Current Zoning: R-5 AIR (single family residential, Airport Noise Overlay), B-2 AIR (general business, Airport Noise Overlay)
Proposed Zoning: UR-2(CD) AIR (urban residential, conditional, Airport Noise Overlay)

Approximately 7.7 acres located on Tennyson Drive near Interstate 85.

The petition proposes to allow 38 single family attached residential dwelling units on a vacant site in the Enderly Park neighborhood.

SHEET:	PROJECT:	TENNYSON TOWNHOMES SCHEMATIC SITE OVERALL PETITION 2022-125 610 TENNYSON DR. Charlotte, NC 28208

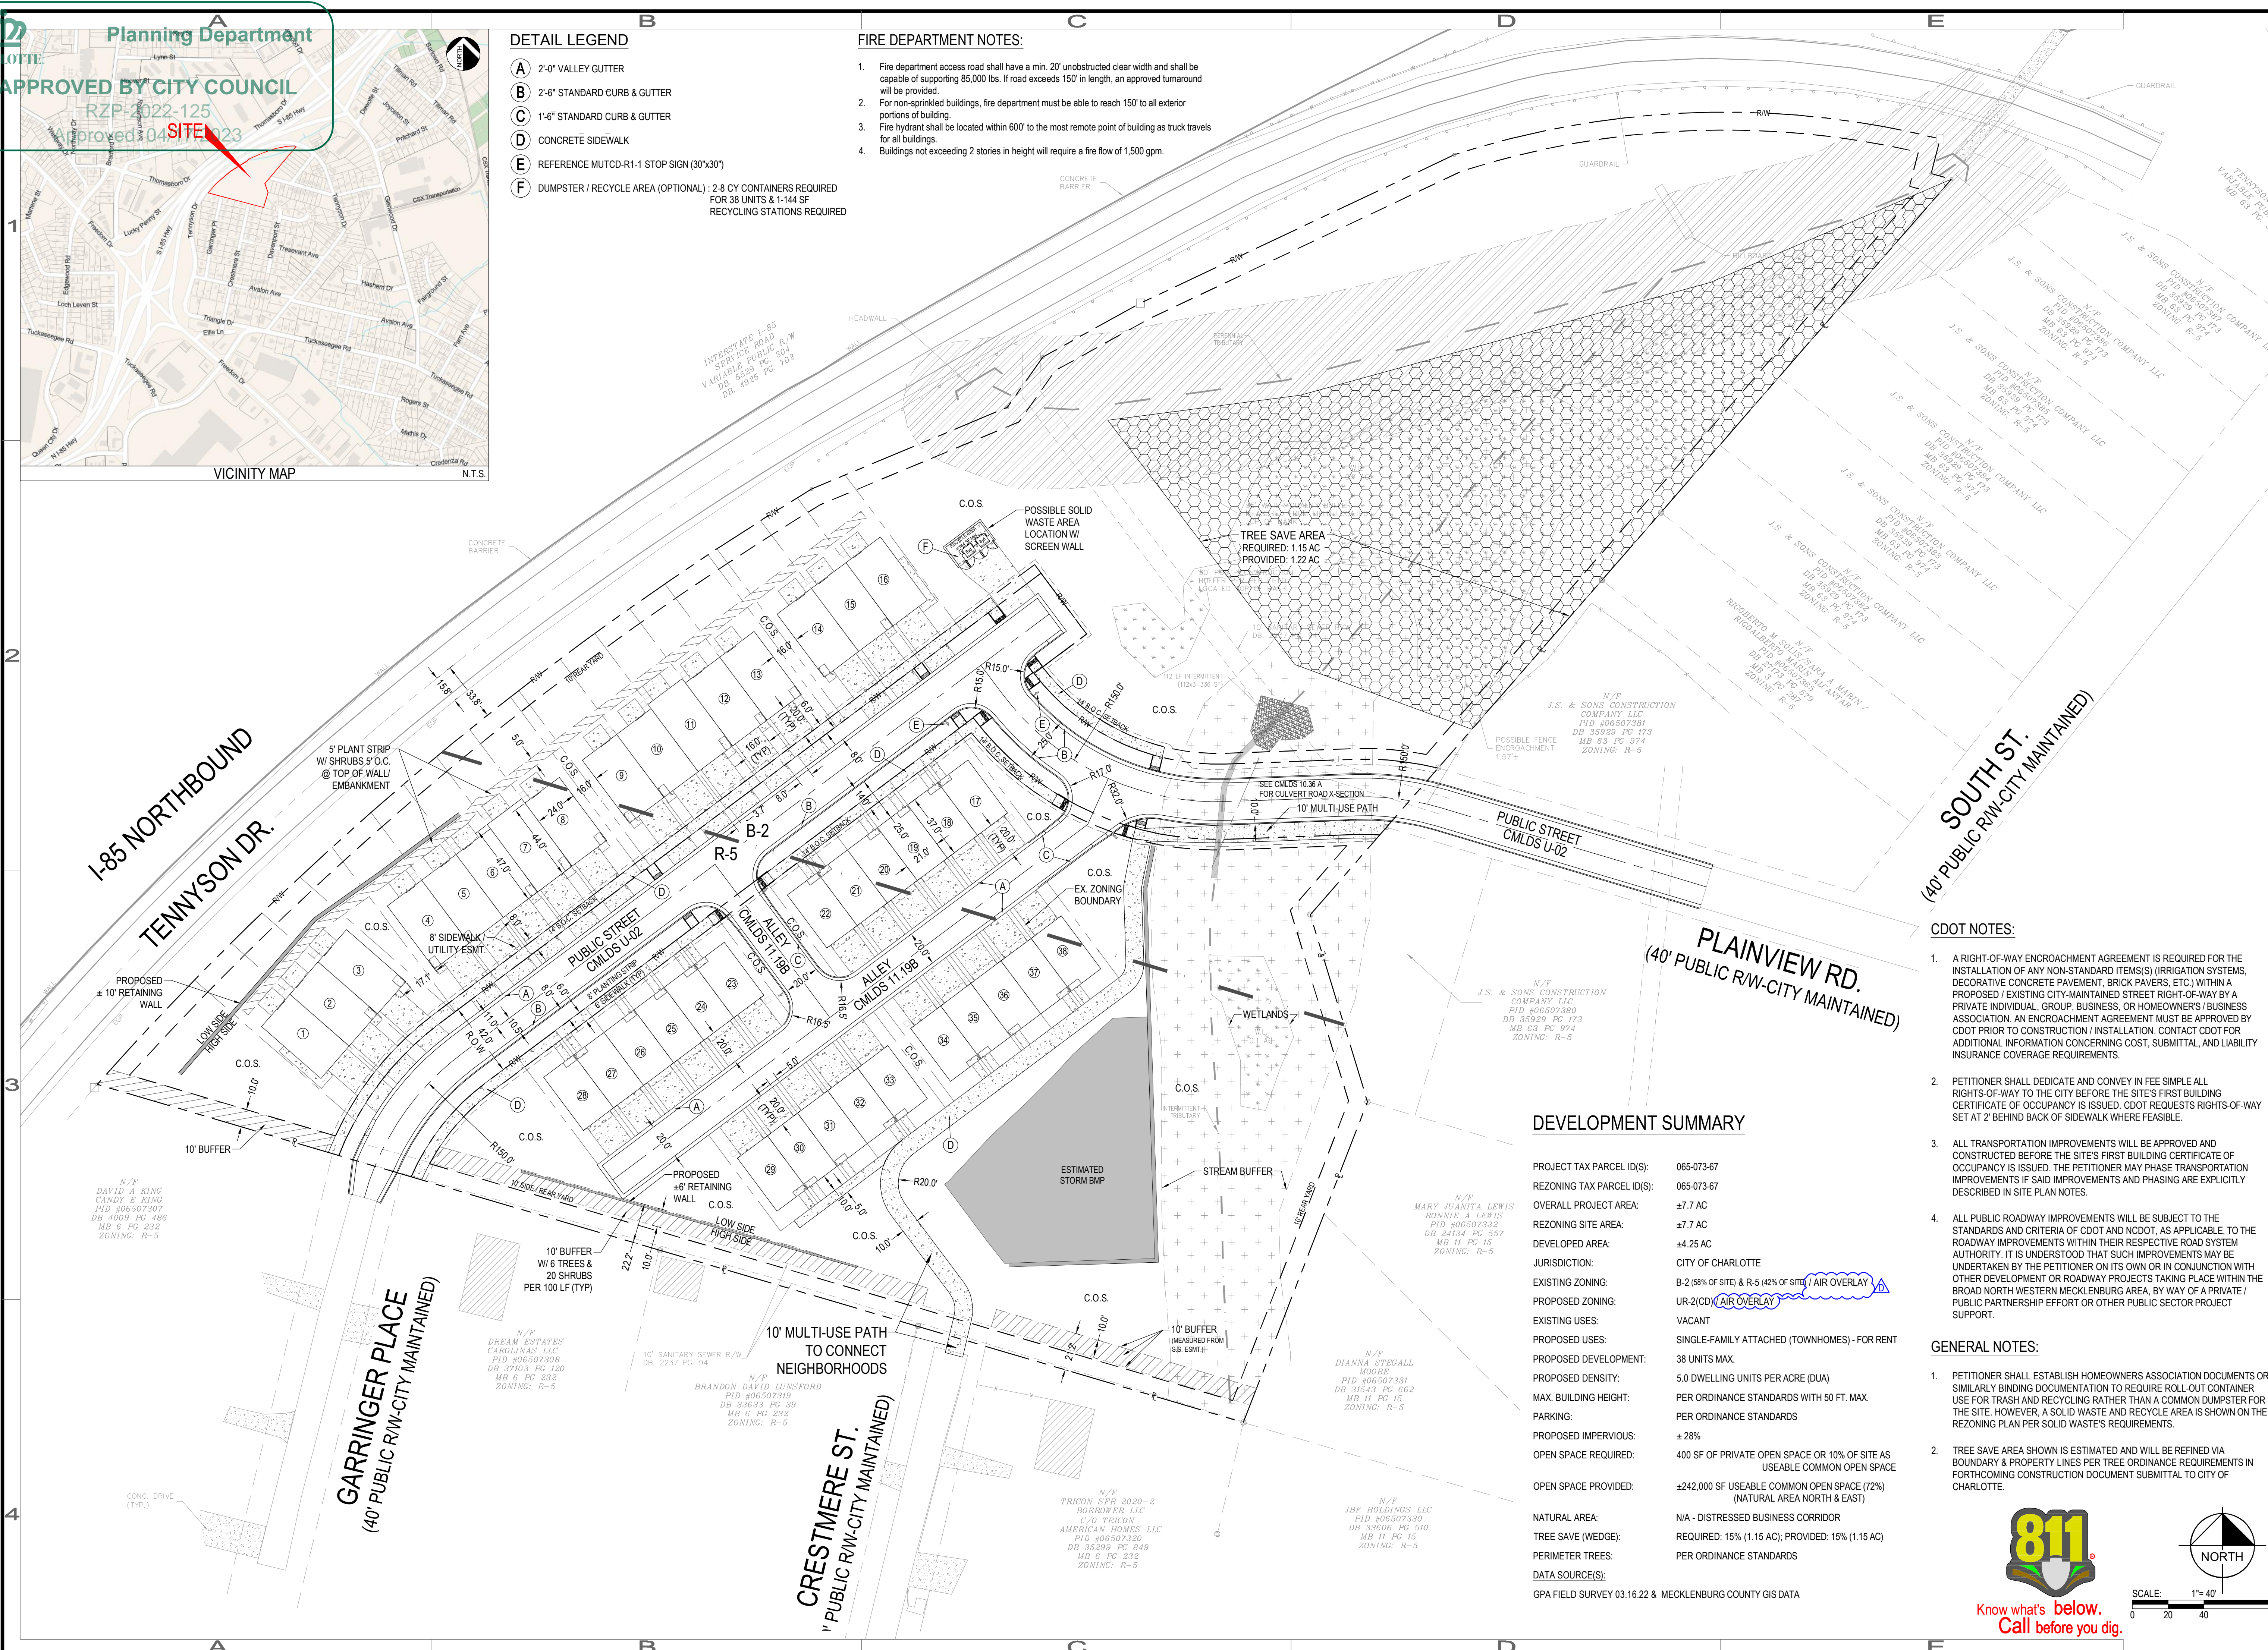
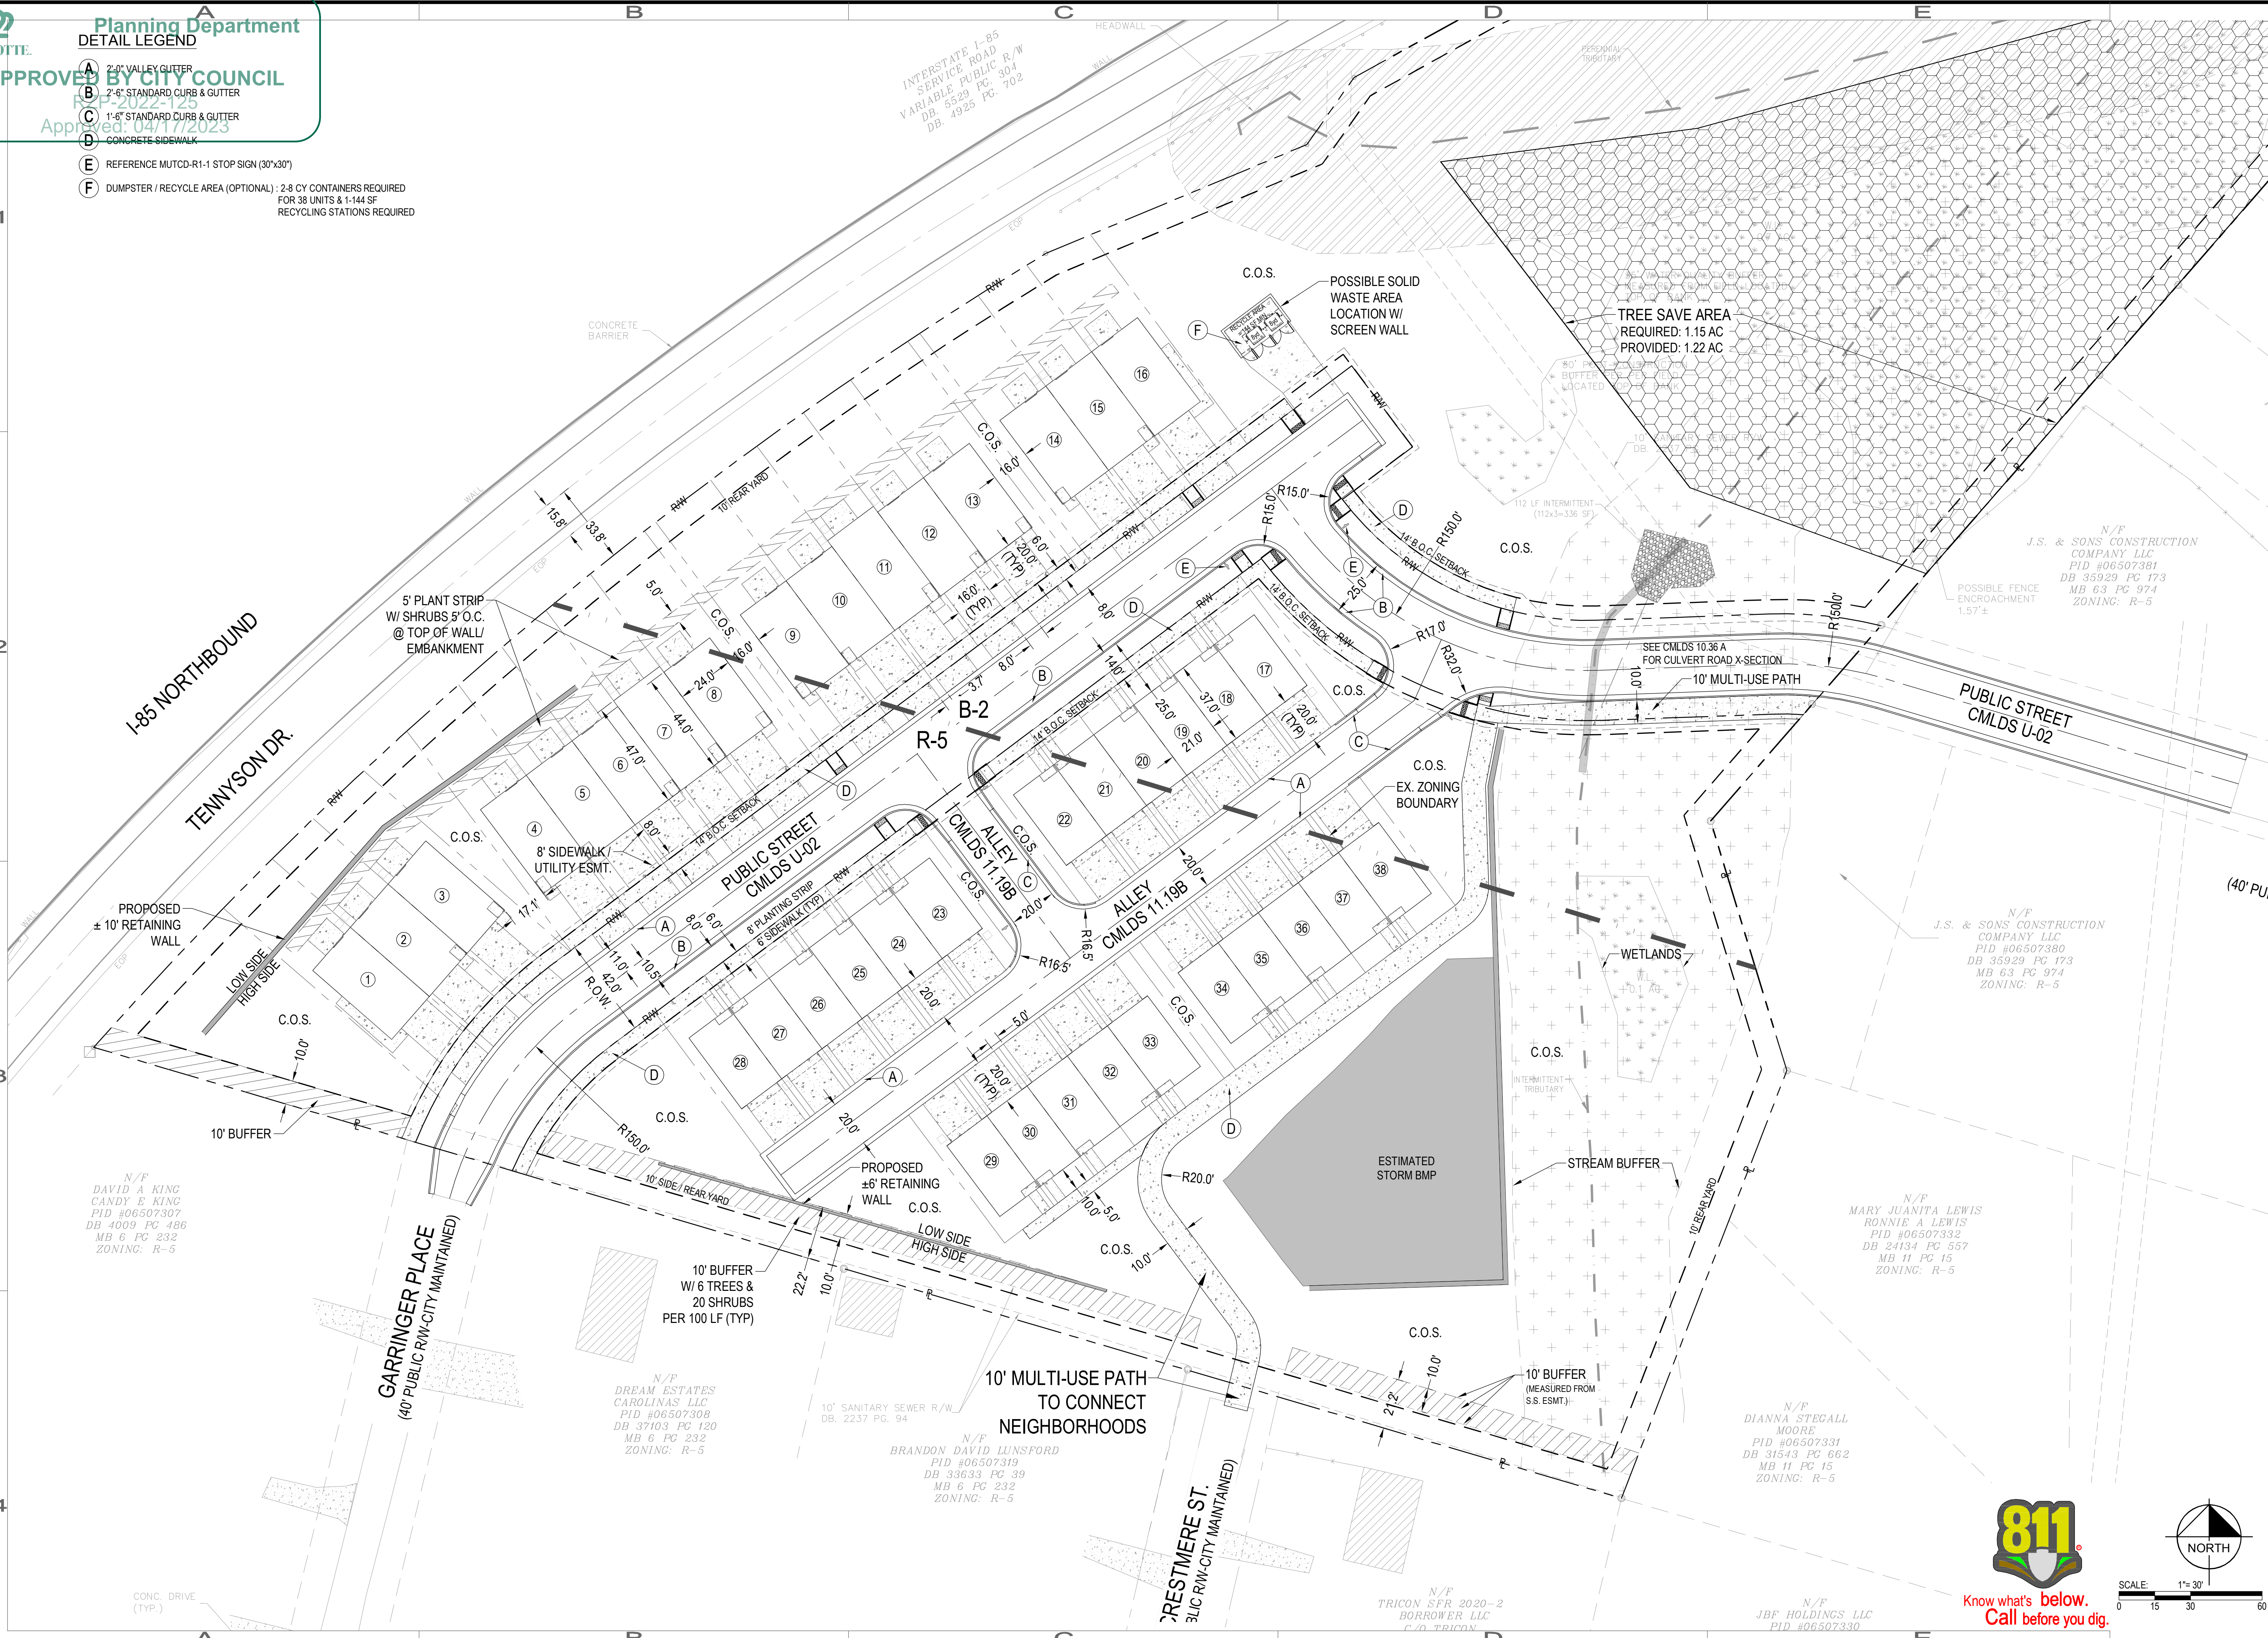
1. ~~Add "AIR" to both the existing and proposed zoning on site plan. This site is within the Airport Noise Overlay, abbreviated as "AIR".~~ **ADDRESSED**

2. ~~Revise roadway design to remove 90 degree turn and satisfy CDOT standards for public roadway geometry.~~ **ADDRESSED**
